STATE OF NORTH CAROLINA
DEPARTMENT OF TRANSPORTATION

Addendum No. 3

RE: Contract # C203980

SR-1409 (MILITARY CUTOFF ROAD EXTENSION) FROM SR-1409 TO
US-17 IN WILMINGTON

PROJECT REFERENCE NO. U-4751		SHEET NO. 8	
RW SHEET NO. ROADWAY DESIGN ENGINEER		HYDRAULICS ENGINEER

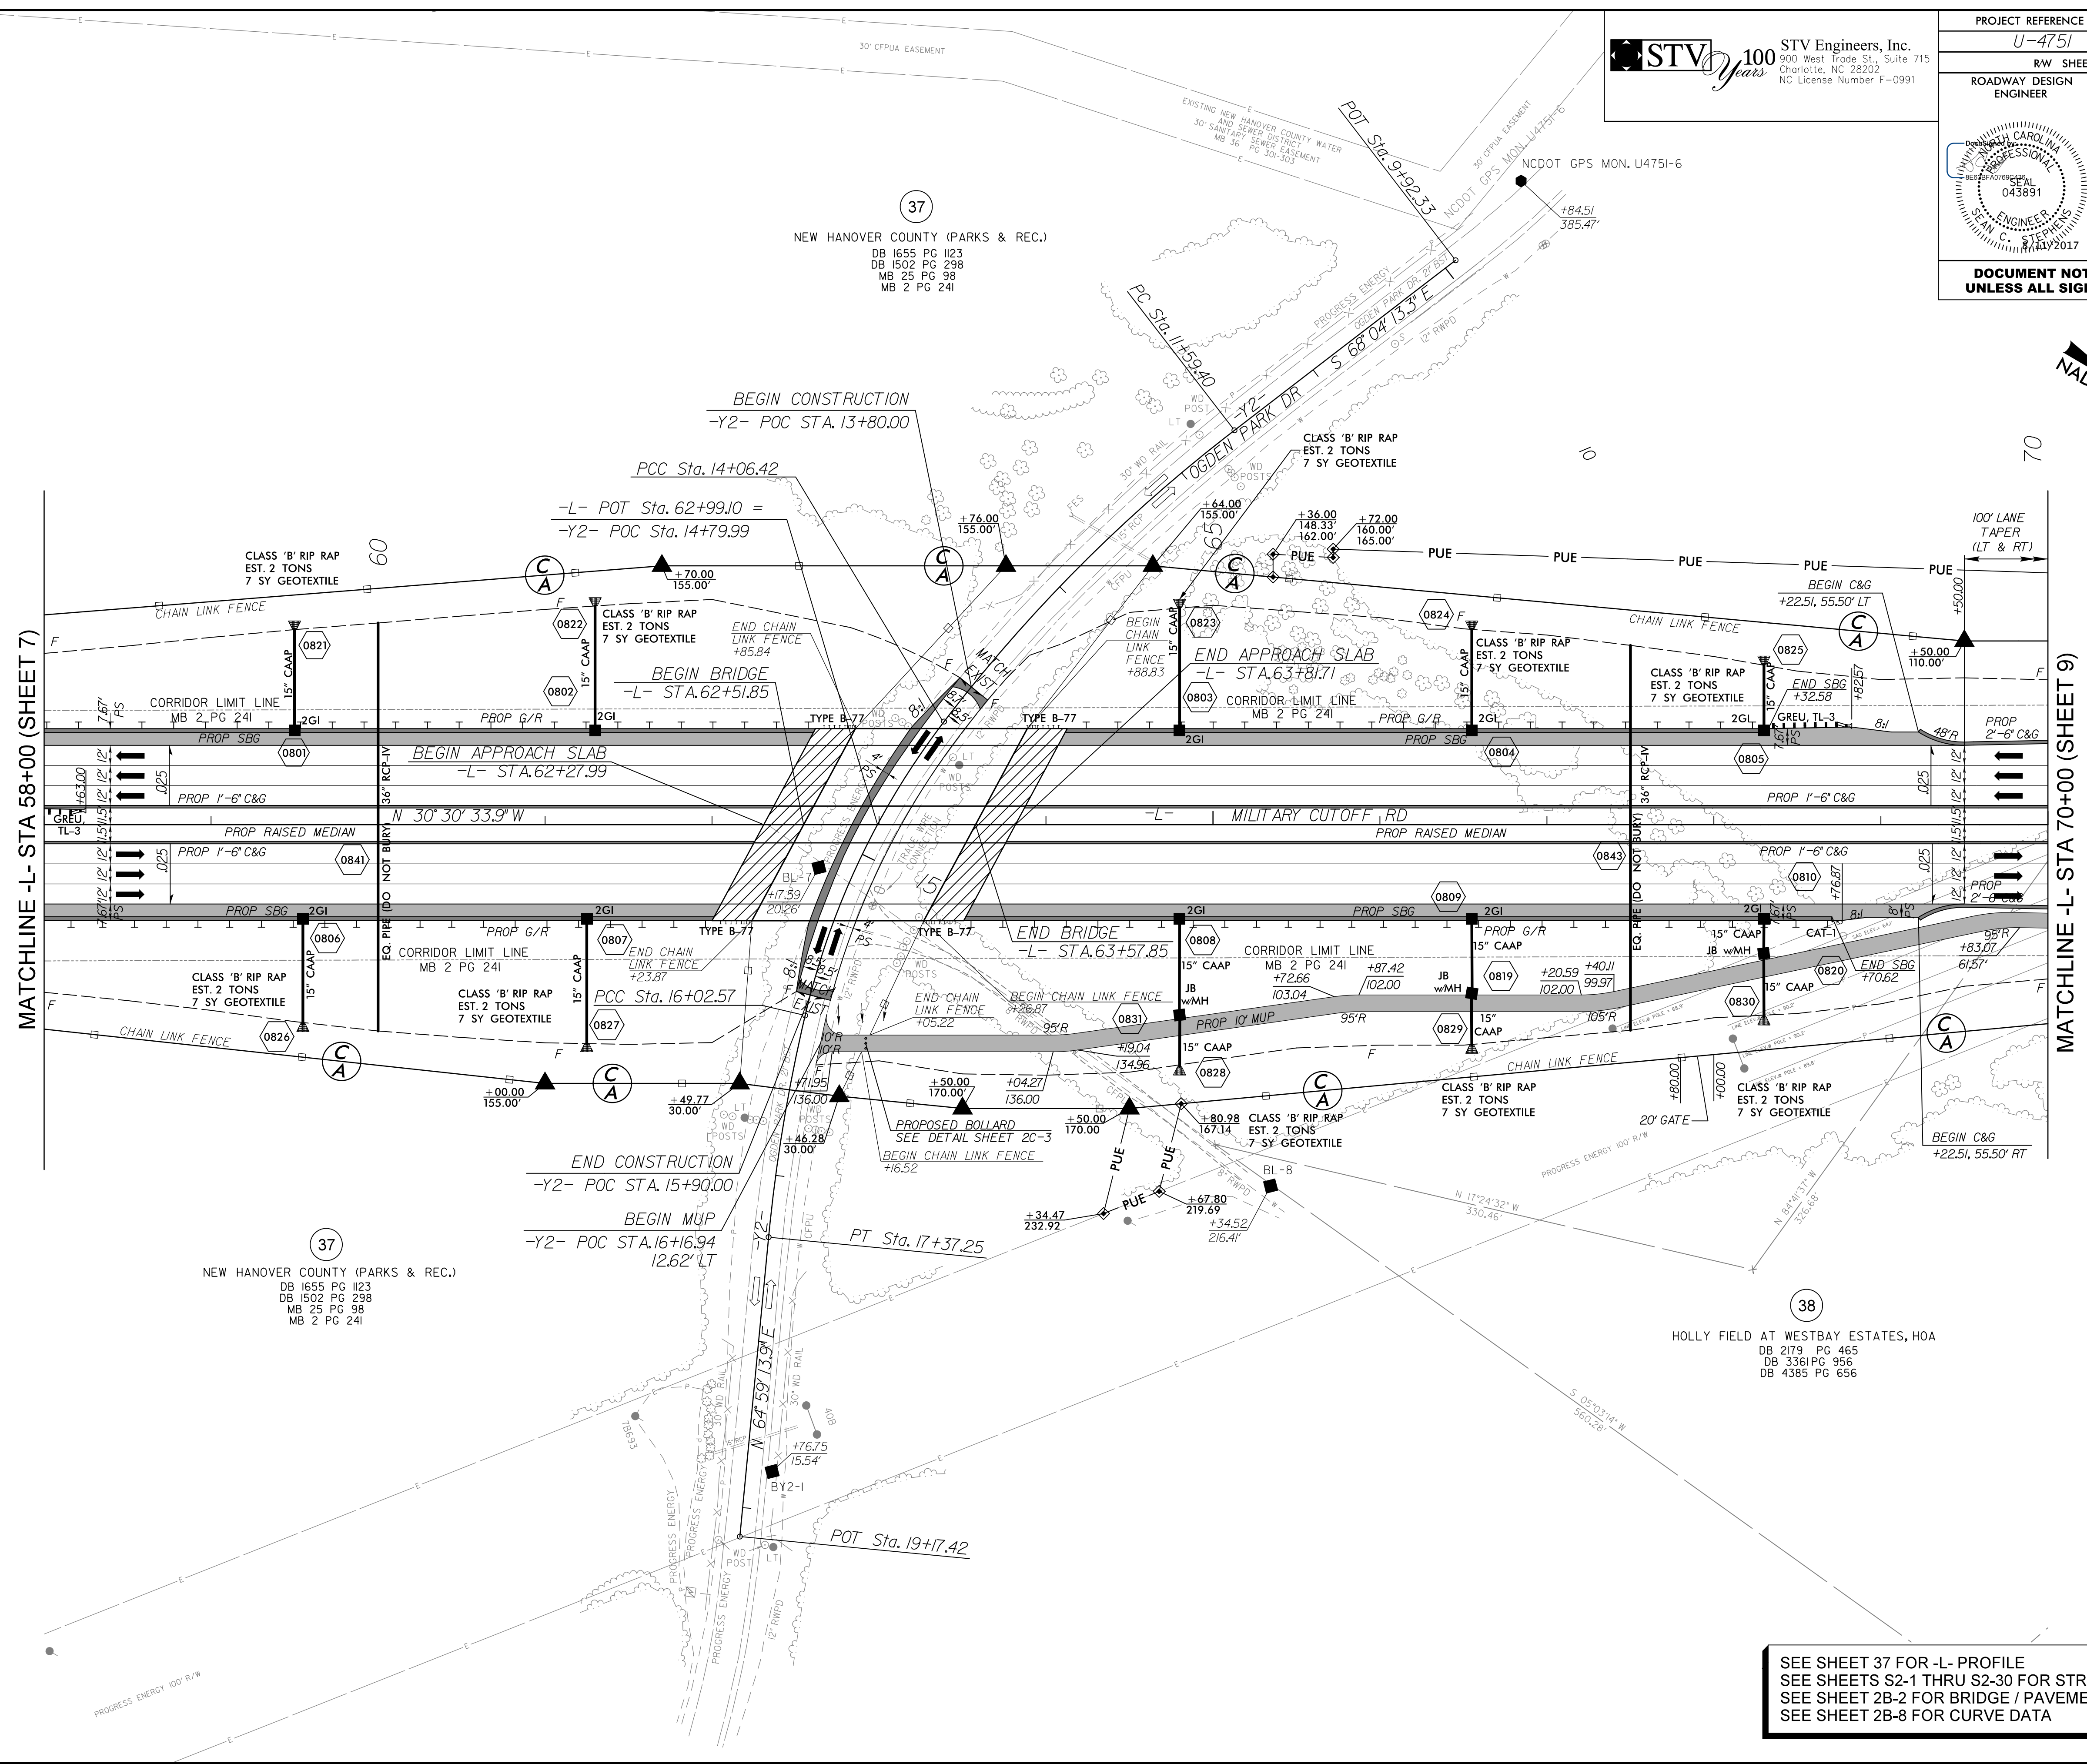
Sheet No.	Revisions
1-A	Revised to show New Sheet No. 2G-5 among the Geotechnical details
2C-22	Revised to add additional curb ramp detail for use at multi-use path
2G-5	New sheet to include the Standard Rock Plating detail
4 thru 34	Revised to include wetland boundary delineations (Note: Only Sheets 4-10, 15-23, 21A, 25-27 and 30-34 have wetlands on them)
